ADC PARKS & GREENSPACE ARBORICULTURE

PLANNING APPLICATION: EG/39/15/TC

ADDRESS: Brook Cottage Church Lane Eastergate PO20 3UT

BRIEF DESCRIPTION: Reduce crown of 1 No. Willow tree to leave height of 8.5m, reduce crown of 1 No. Weeping Willow Tree to leave height of 10m & reduce crown of 1 No. Walnut tree to leave height of 8.5m within the Eastergate (Church Lane) Conservation Area.

Brook Cottage, Church Lane, Chichester, PO20 3UT

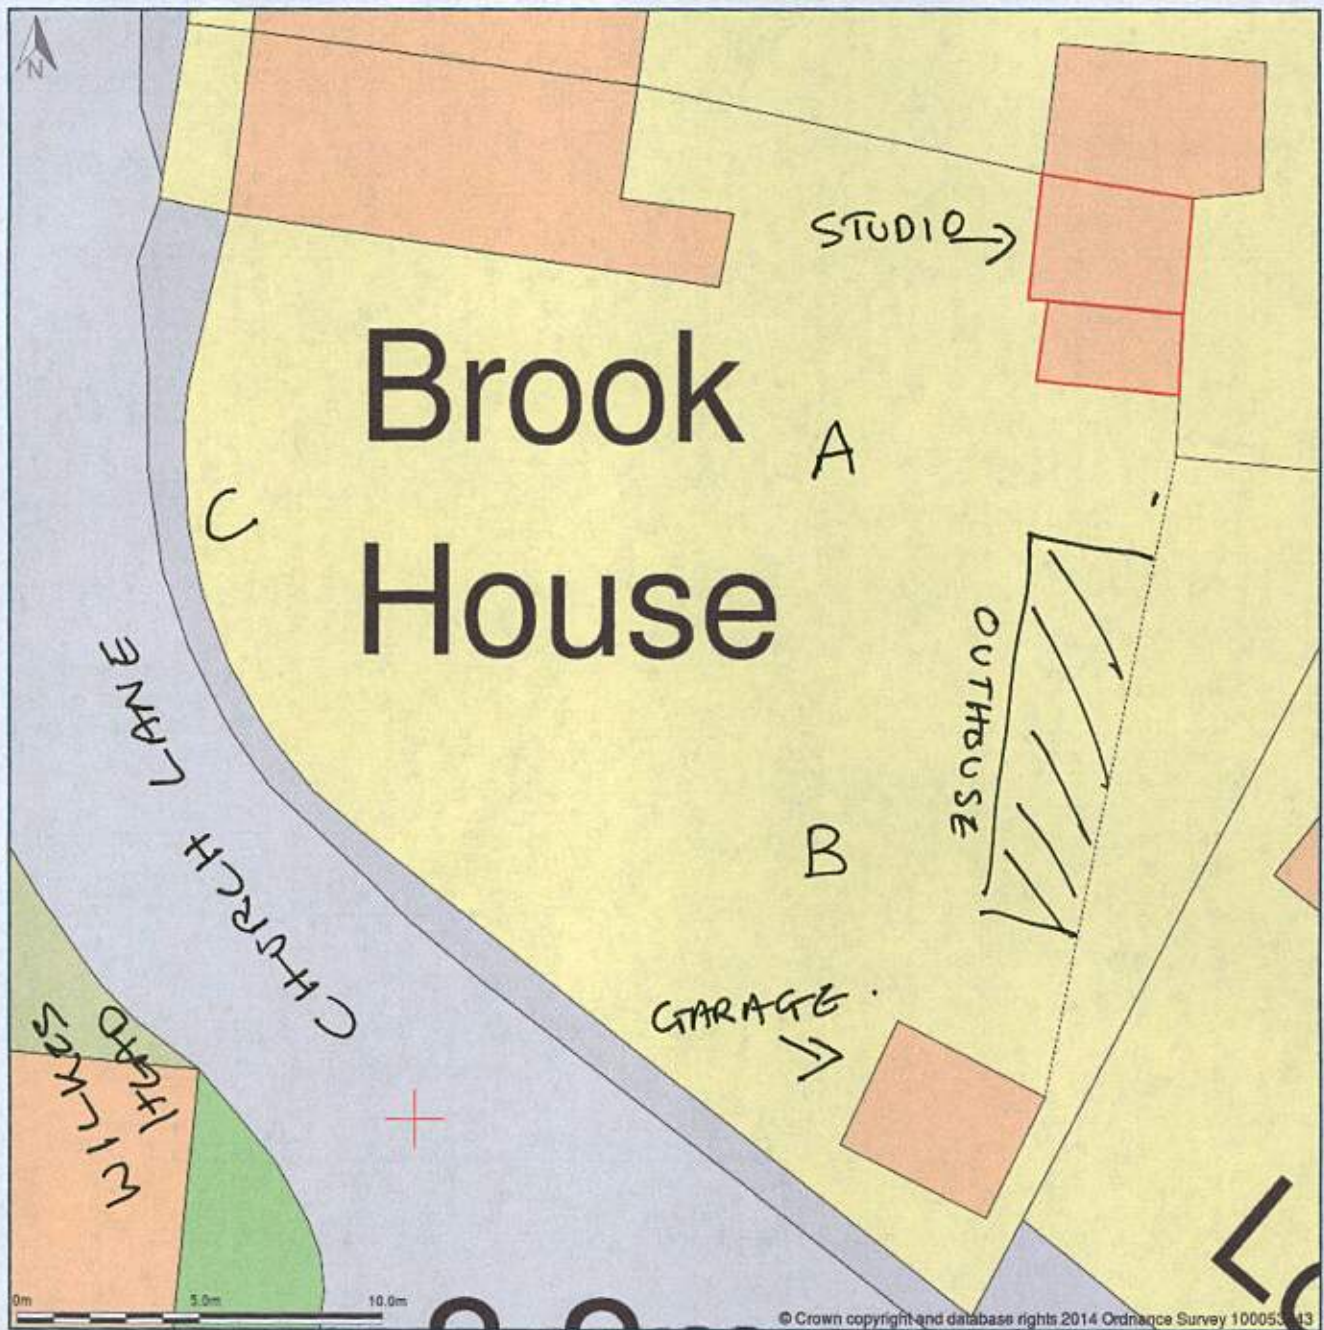
- The trees highlighted in this application are not covered by a TPO; however they are situated in a conservation area.
- The applicant has applied for the following reductions;
 1. For **T1**, the applicant has applied to reduce back to the previous points. This would equate to a final top height of 10 meters. This action is unlikely to have a lasting negative impact to **T1**.
 2. For **T2**, the applicant has applied to reduce back to the previous points. This would equate to a final top height of 8.5 meters. This action is unlikely to have a lasting negative impact to **T2**.

3. For **T3**, the applicant has applied to reduce back to the previous points. This would equate to a final top height of 8.5 meters and a crown lift of 1.5 meters. This action is unlikely to have a lasting negative impact to **T3**.

- As the proposed operations are unlikely to have a negative impact on trees **T1 – T3**, **I would have no objection to the proposed pruning operations.**
- When completing the proposed operation, it is **suggested** the attached drawings are followed.
